CITY OF ALBUQUERQUE

July 27, 2016

Re: Clean Machine Carwash
4200 San Mateo Blvd., NE
Traffic Circulation Layout
Engineer's/Architect's Stamp **6-9-16** (G18-D049)

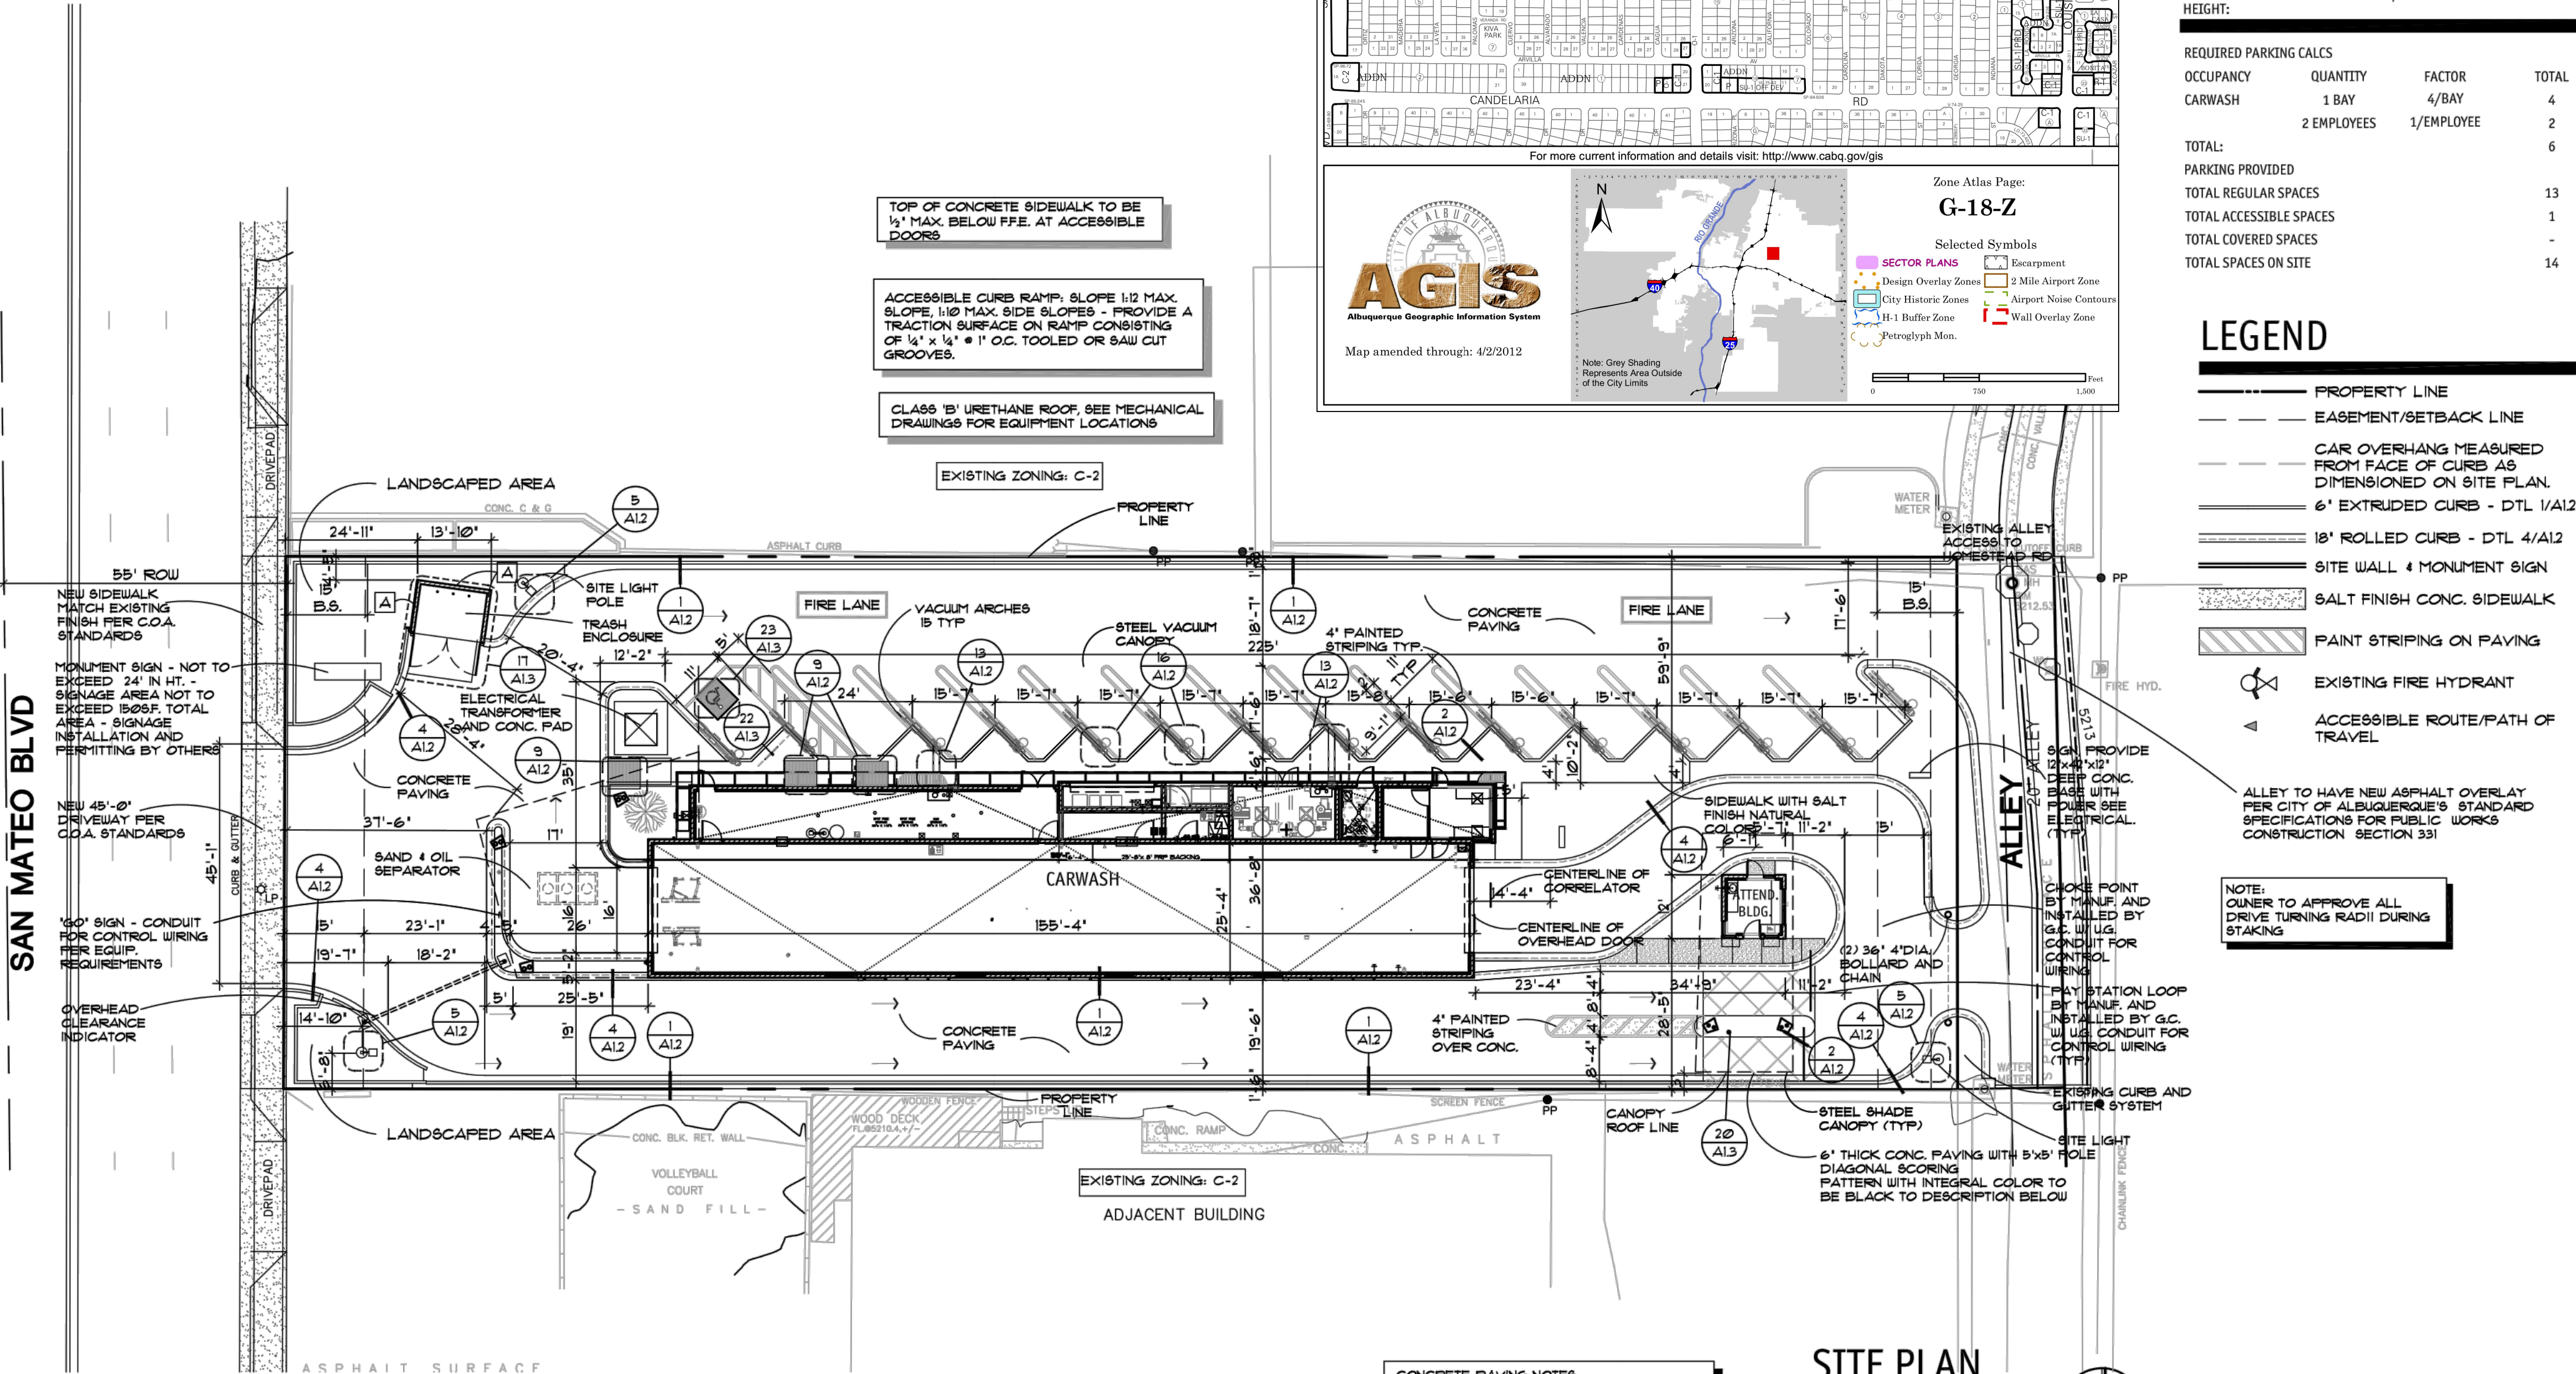
1. Clarify circulation of vehicles at the main entrance on San Mateo Blvd. There appears to be conflicting vehicle movements. Please add detail of directional arrows and signage.
2. Detail and dimension bicycle and motorcycle parking spaces, along with appropriate signage.
3. The ADA accessible parking sign must have the required language per 66-7-352.4C NMSA 1978 **"Violators Are Subject to a Fine and/or Towing."** Please call out detail and location of HC signs. See attached 2009 NM Accessible Parking Checklist page 3 of 6.
4. One-way vehicular paths require pavement directional signage and a posted **"Do Not Enter"** sign at the point of egress. Please show detail and location of posted signs.
5. Please specify the City Standard Drawing Number when applicable.
6. Please include two copies of the traffic circulation layout at the next submittal.
